**Consultation Response from KC, Highways Development Management**
**2020/90182 adj High Beeches, 585, Manchester Road, Linthwaite, Huddersfield, HD7 5QX**
**Erection of two semi-detached dwellings with attached garage and off road parking**
**Date Responded: 03/03/20**
**Responding Officer: CNB**
**Responding Ref: K2-2/14**

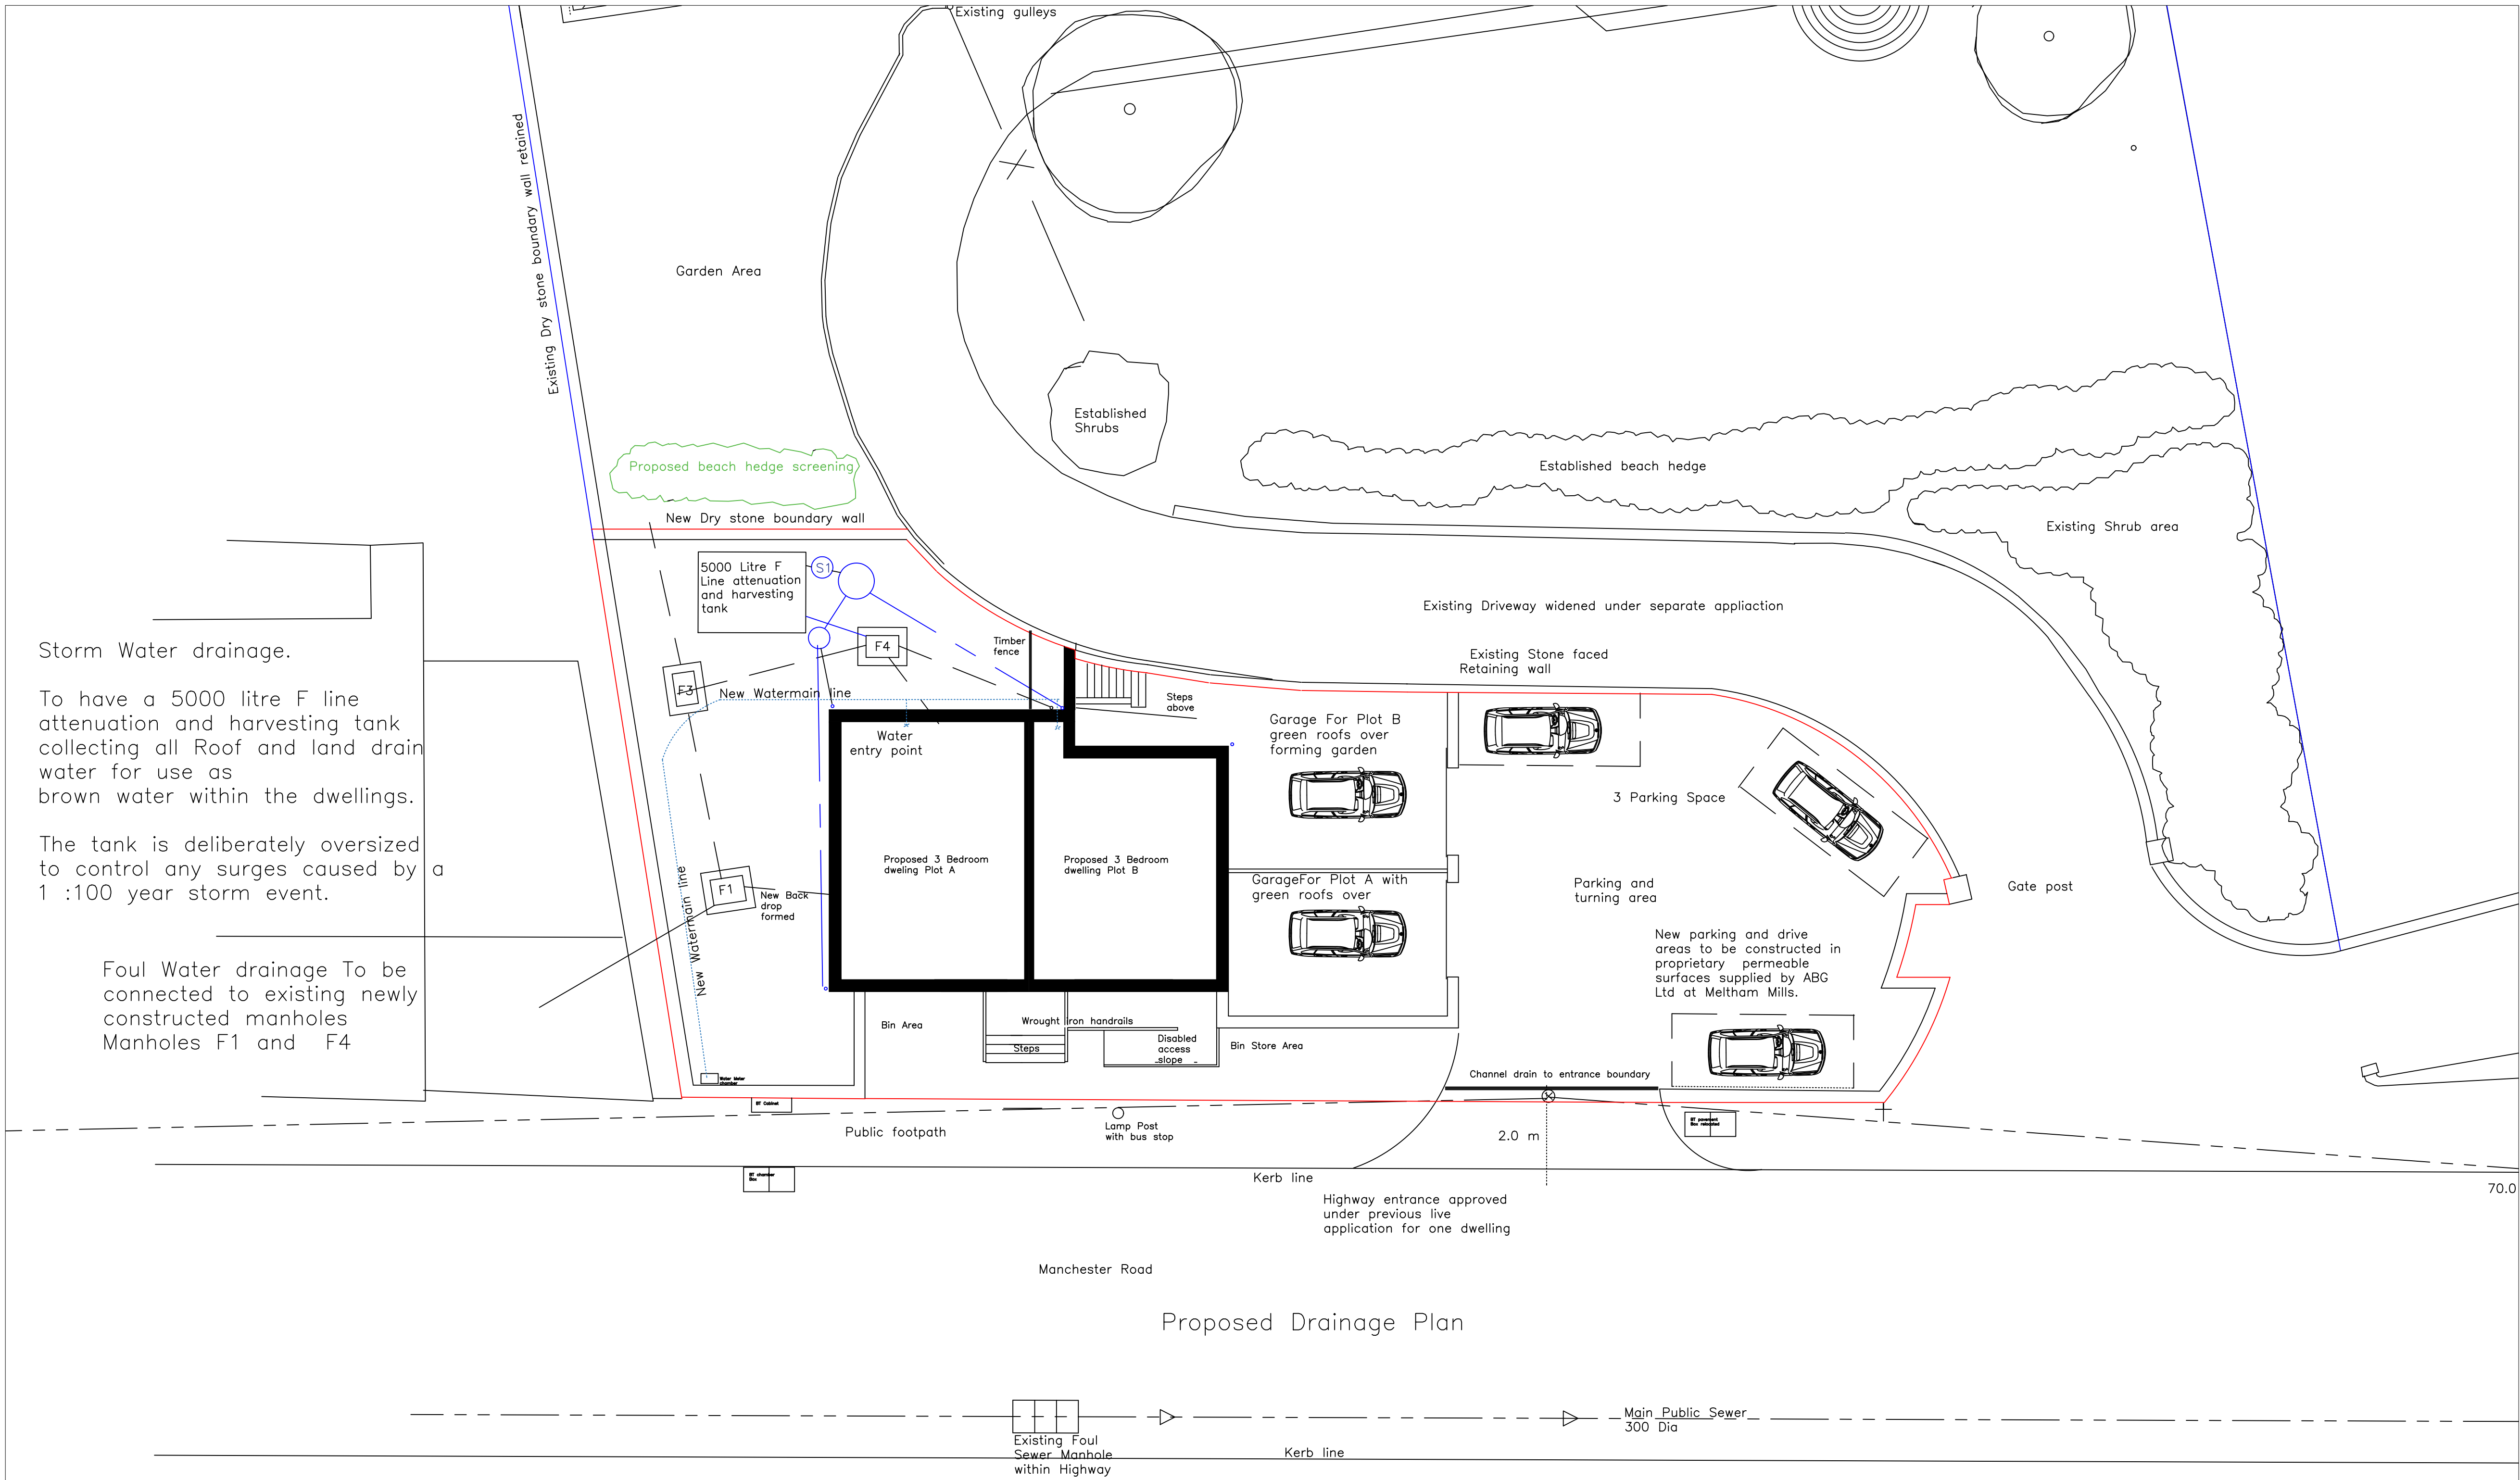
A revised layout drawing (HBBP/2019/20 Rev A) showing the removal of attached garages and an increase in off street parking.

Drawing HBBP/2019/20 Rev A shows parking for 4 vehicles with suitable turning space to allow the vehicles to enter/exit the site in forward gear. This would be fit for purpose for two three-bedroom dwellings and is acceptable.

The drawing shows two gated bin storage enclosures to the front of the dwellings and these are suitable for the proposals.
